Your ref:  
My ref: P20/00882

Date: 26<sup>th</sup> January 2021

**48 Berwick Street, London, W1F 8JD,**

**External alterations including installation of replacement glazed roof lantern, rooflights and replacement canopy. Erection of new external staircase. Installation of replacement door and windows at first floor level to rear. Internal alterations including the addition and removal of partitions.**

Project Title 48 Berwick Street, Soho, London W1F 8JD		Job No 3103
Drawing Title Proposed Basement, Ground and First Floor Plans	Drawing No 08	Revision B 12.05.21
Date 03.03.20	Drawn by DA	Checked by GKS

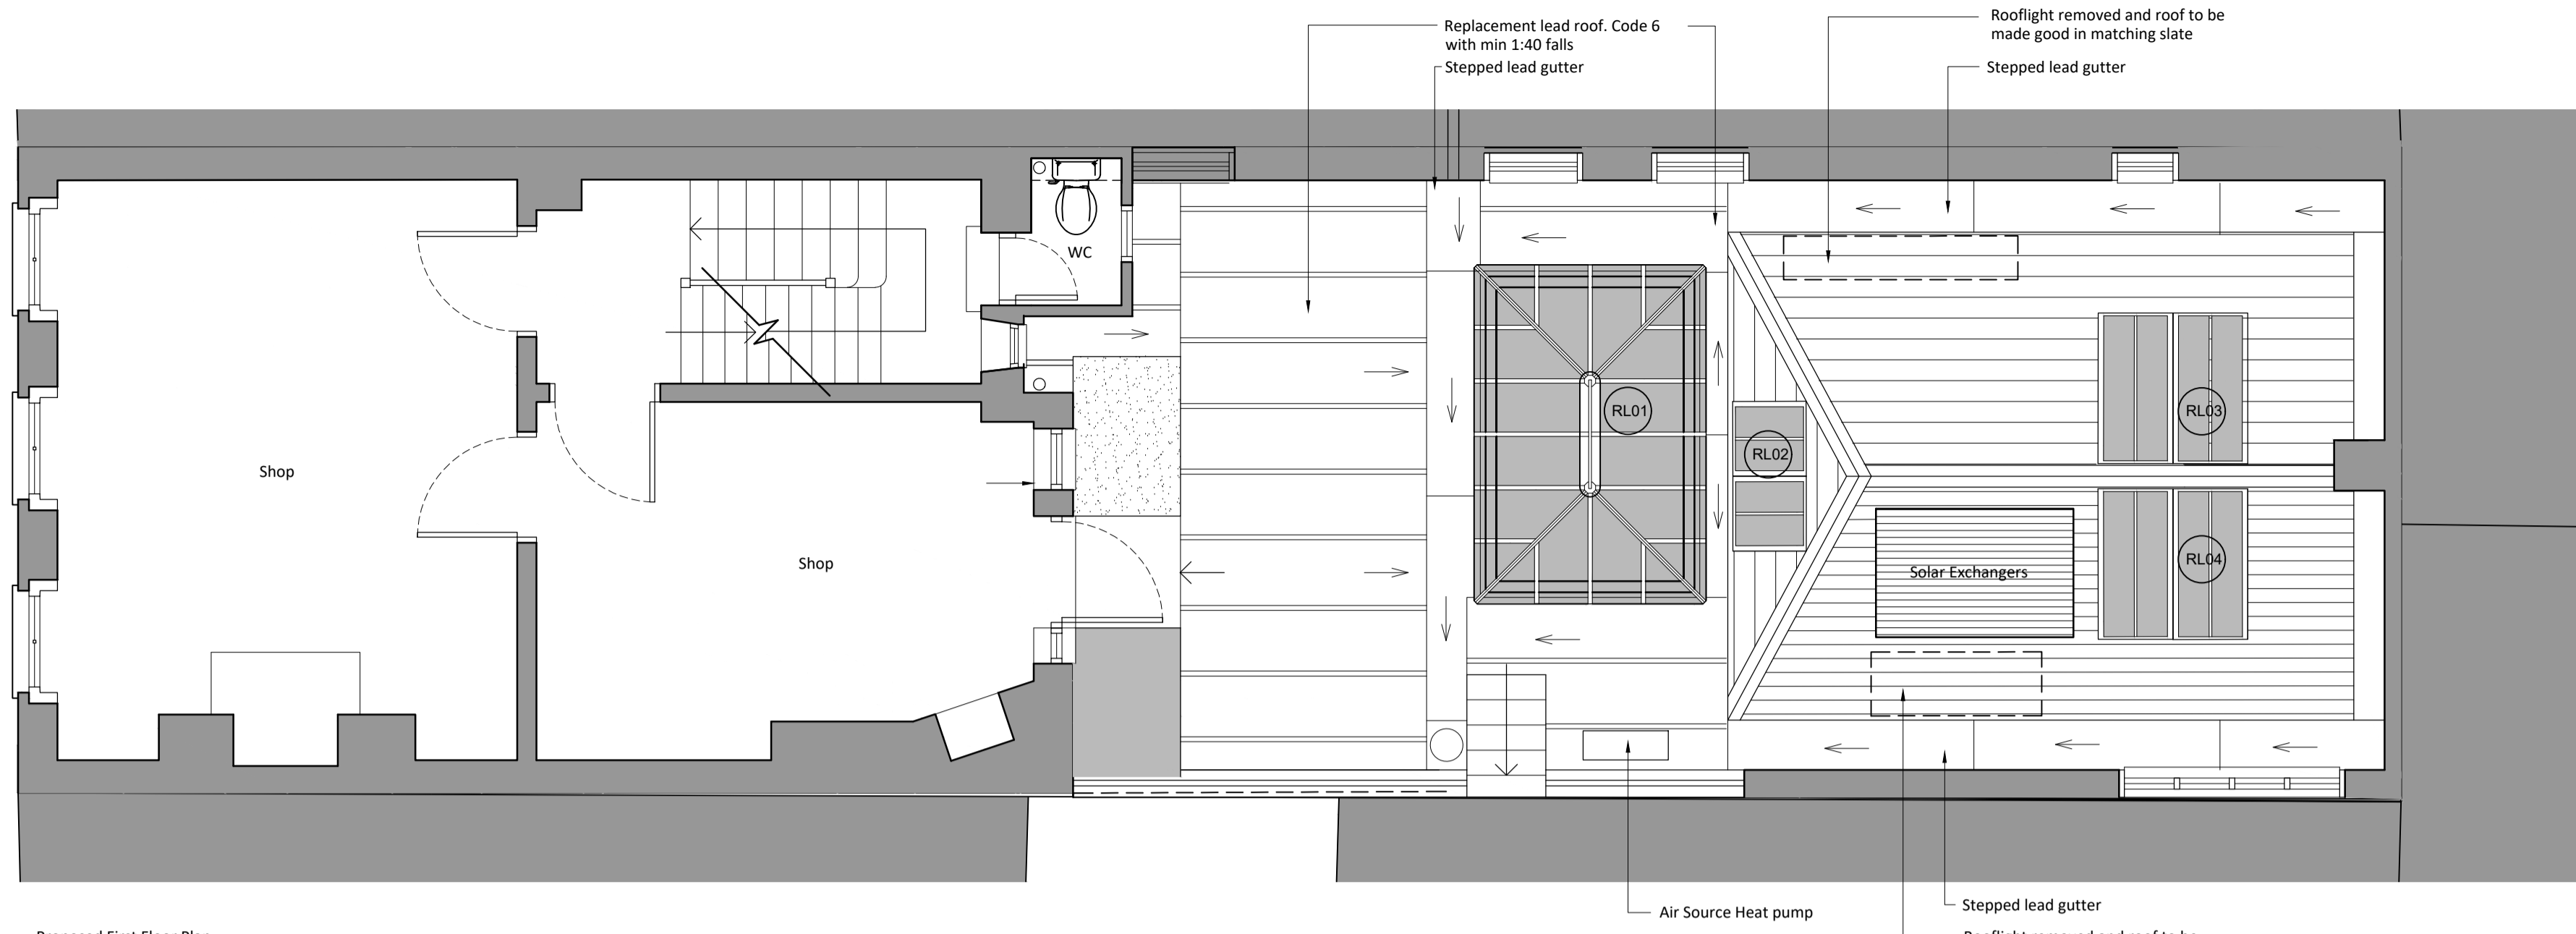
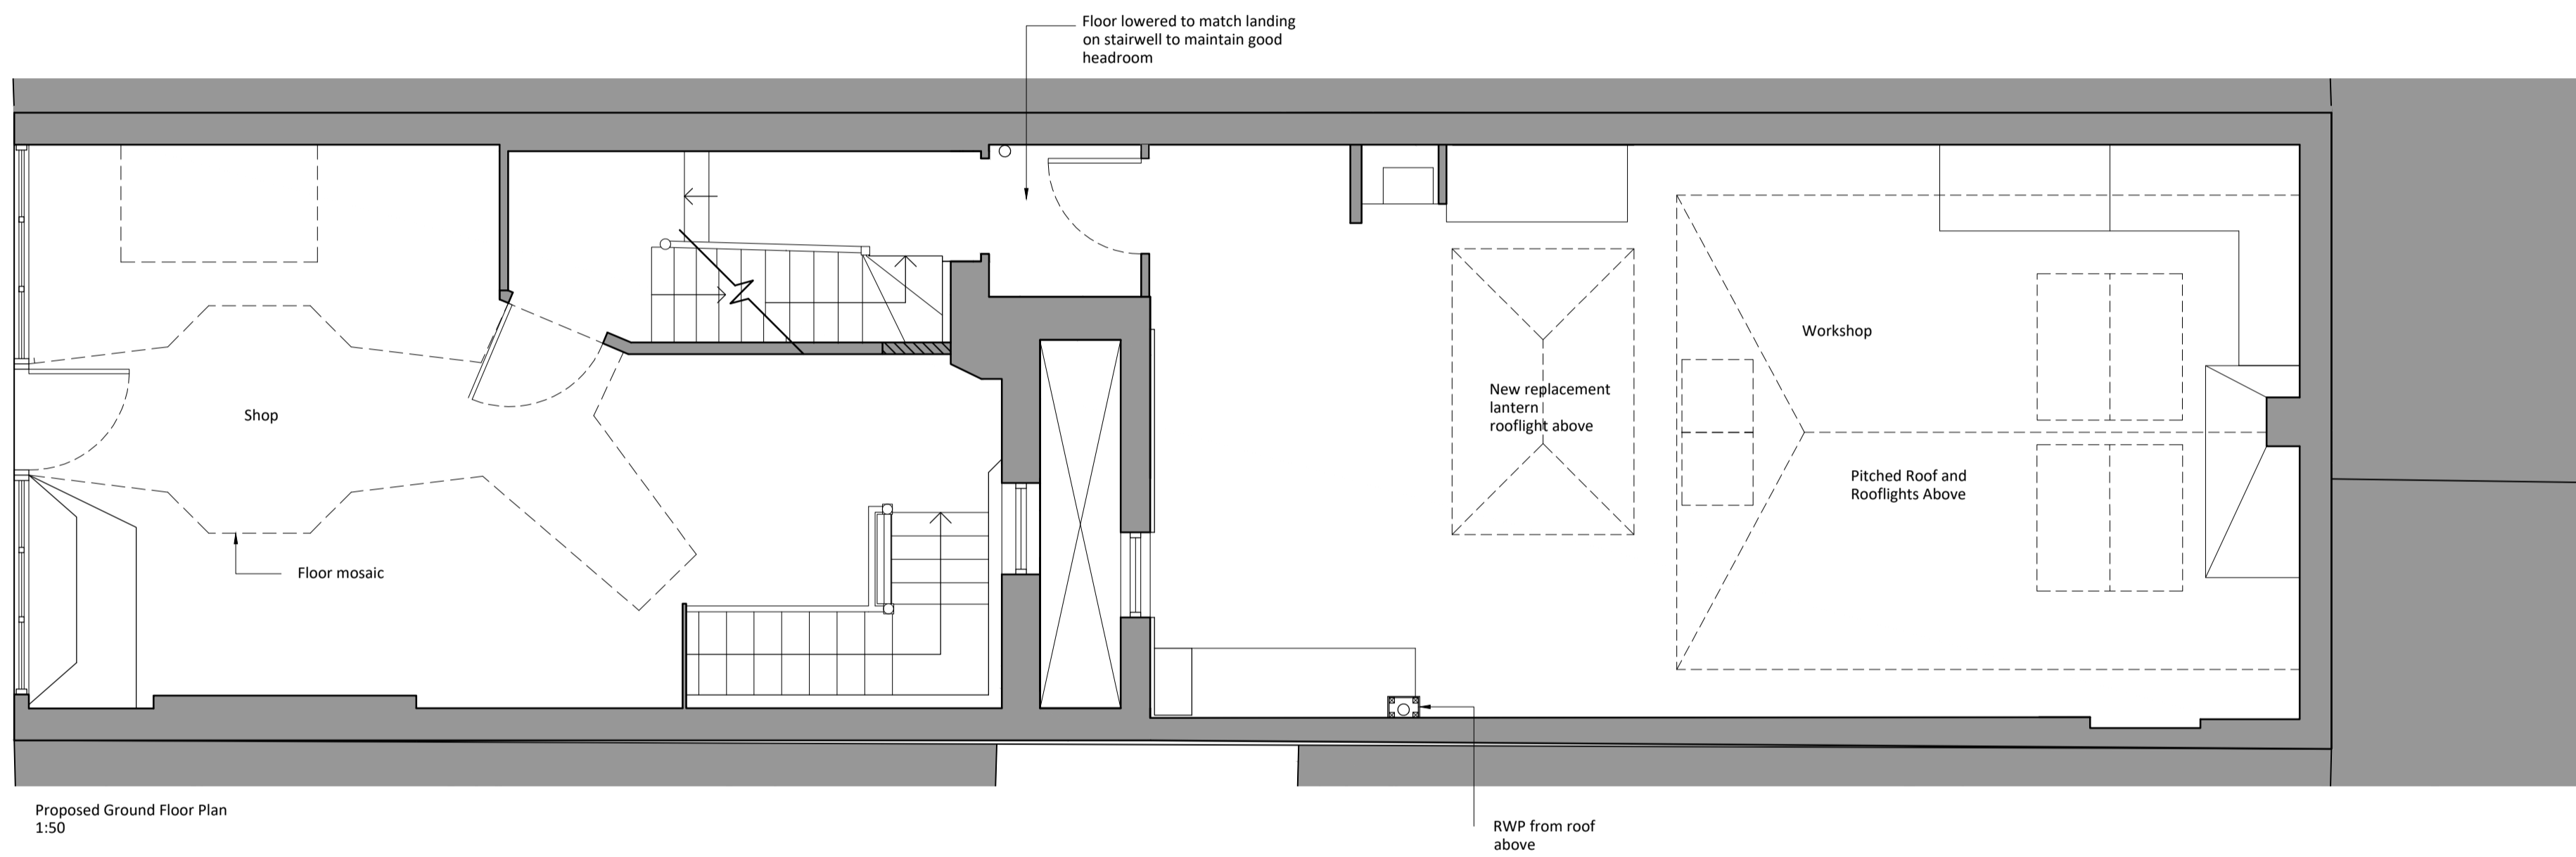
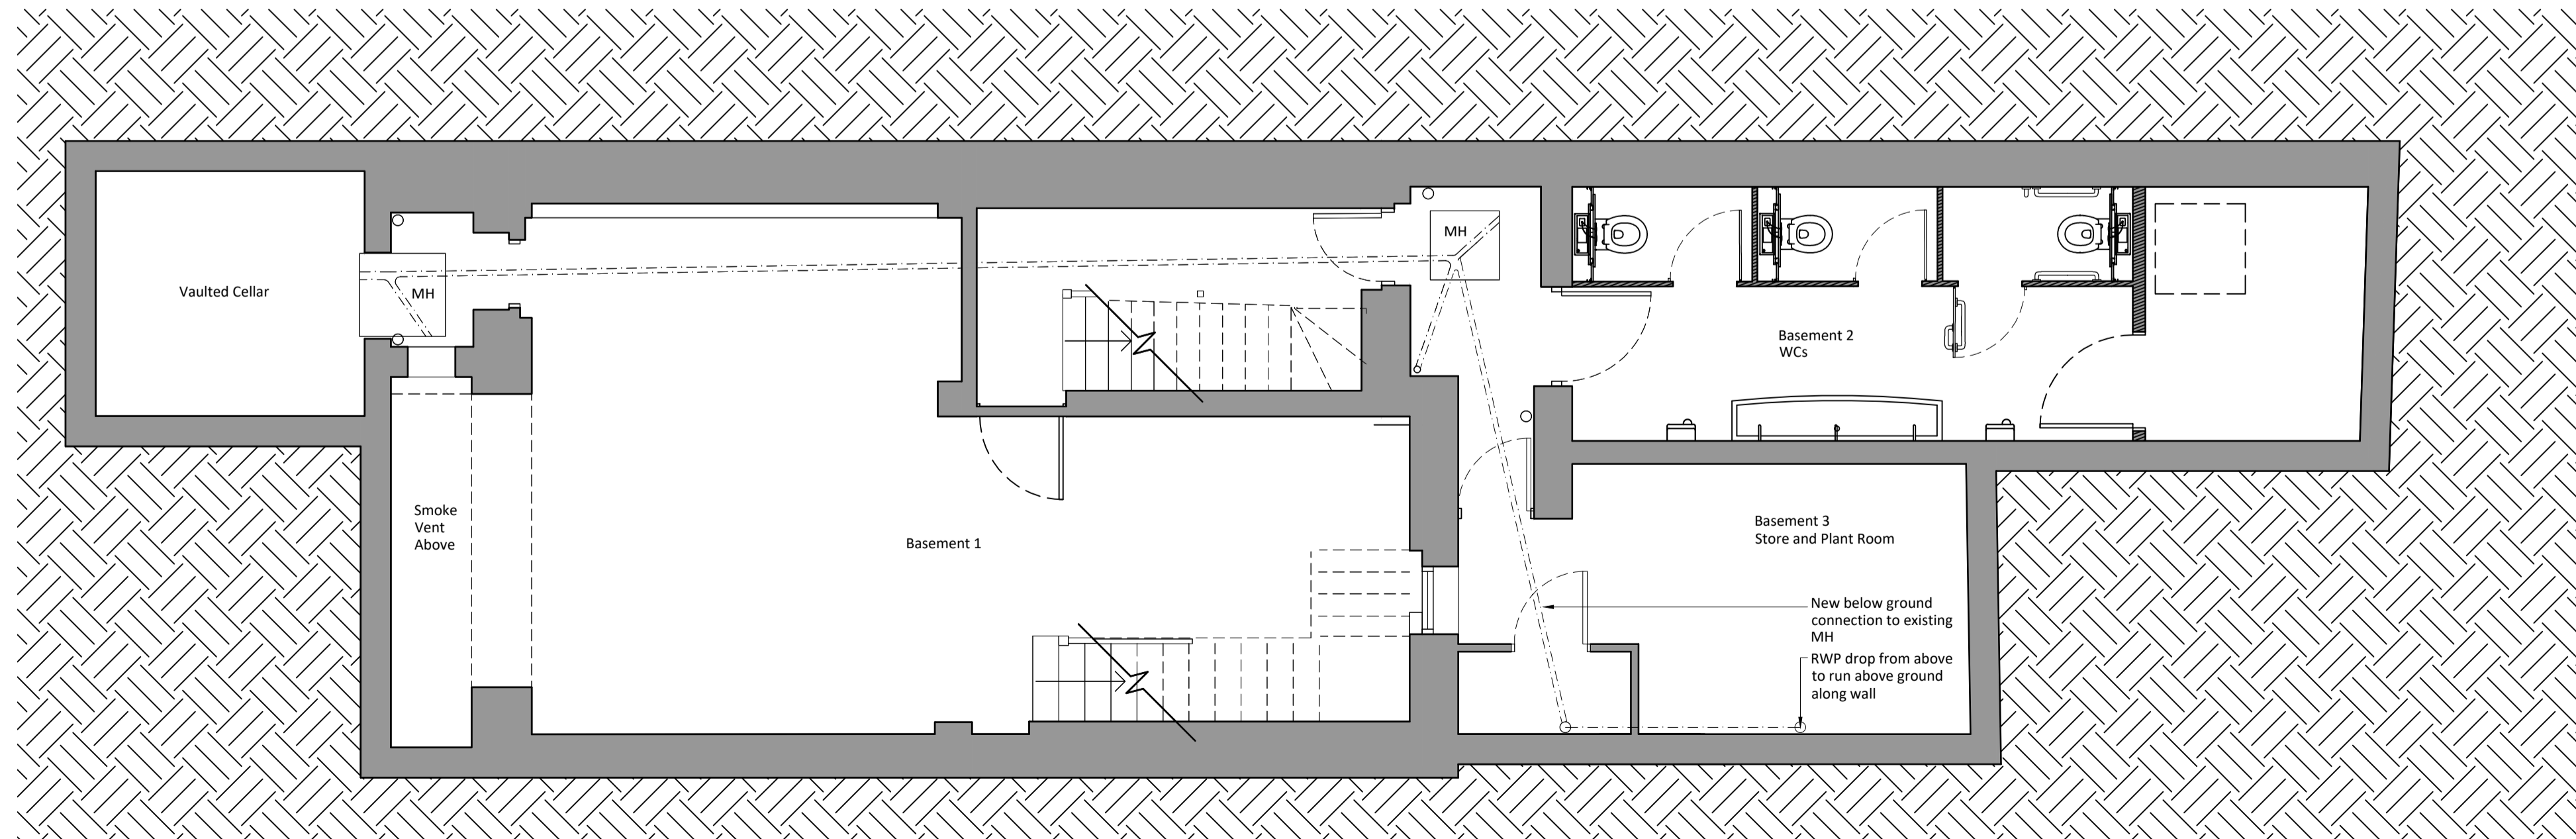
Upon a site visit it became clear that the roof of the rear workshop survives in a poor condition. Extensive repair works may be justified subject to the submission of a structural report and detailed drawings. The replacement of the roof lantern is likely to be acceptable if the proposed replacement is 'like for like' in material and design, a slimline double-glazed timber unit could be justified to provide better sound proofing. The removal of the roof covering and replacement with lead and slate is likely to be acceptable. The addition of natural insulation may also be acceptable. Drawings will need to be provided regarding the repairs to the timber frame below.

Project Title 48 Berwick Street, Soho, London W1F 8JD		Job No 3103
Drawing Title Existing Elevations	Drawing No 04	Revision A
Date 25.11.19	Drawn by LL	Checked by DA
Scale 1:100 @ A3	Note

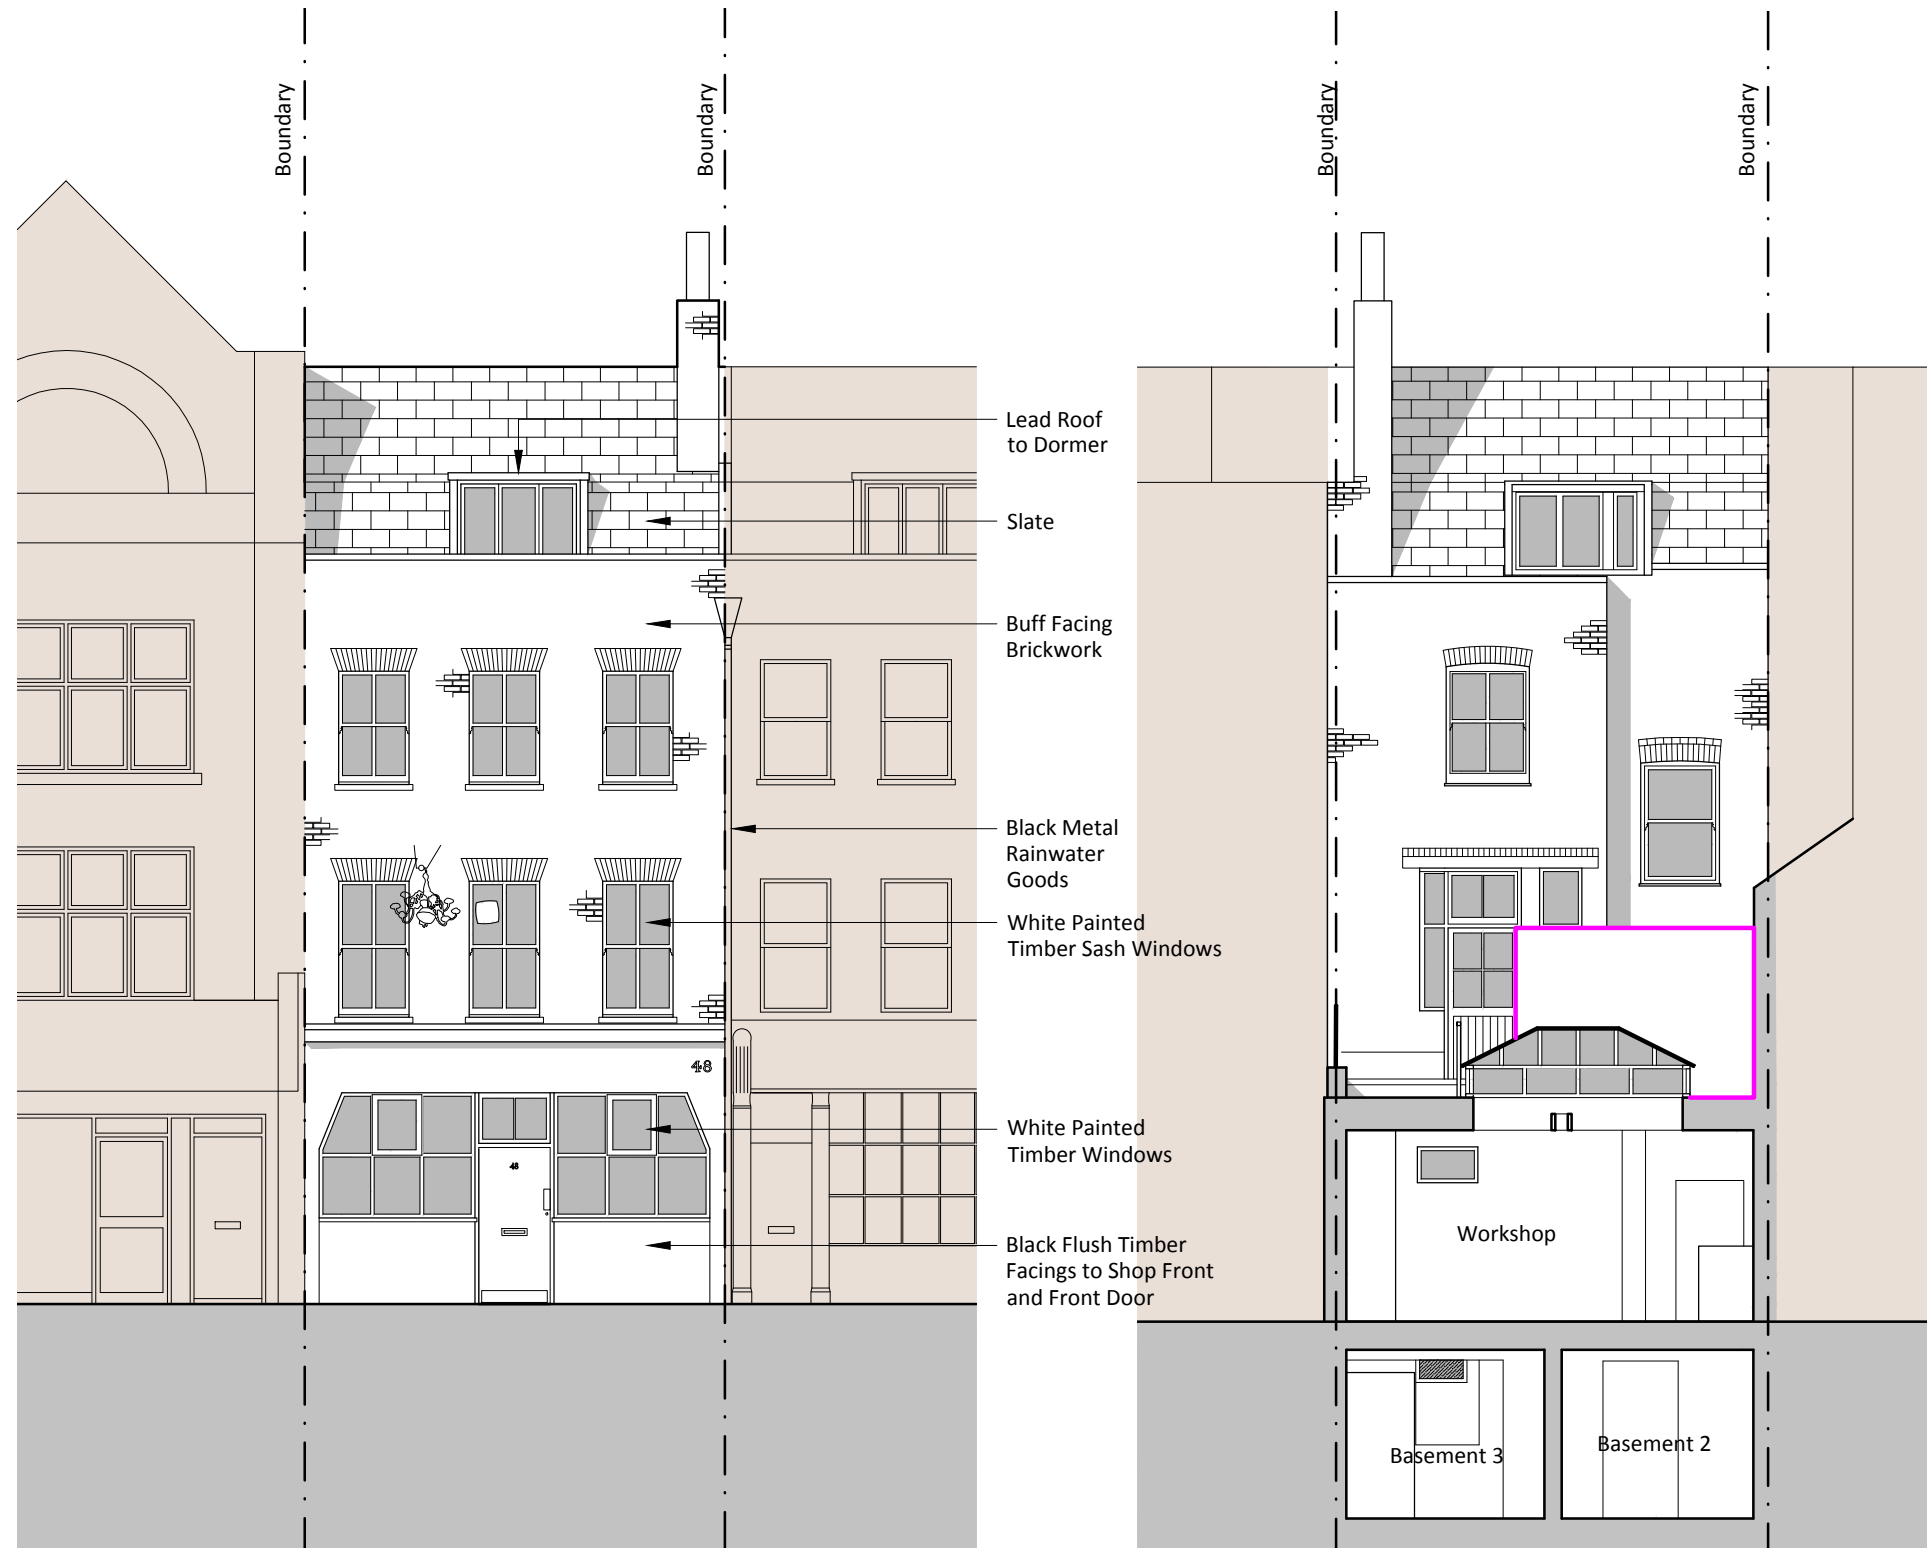
The existing canopy was in place prior to the building's listing, however, its appearance is unsightly, and its removal welcomed. The proposed metal canopy forms an unusual and dominant feature on the rear of this modest terrace. It is likely that no canopy is going to be considered acceptable here.

You are advised to research historic images of the façade to understand its former appearance. The existing shopfront incorporates dark ashlar stone finish and timber framed windows above an unusually high stallriser. It has become a recognisable shopfront on Berwick Street. There is likely to

be no objection to the removal of the shop windows and stallriser and their replacement with a timber framed shopfront with lower stallriser. However, you are advised that the reinstatement of a Georgian style shopfront is most likely to be welcomed. The City Council's 'Shopfront, Blinds and Signs: A
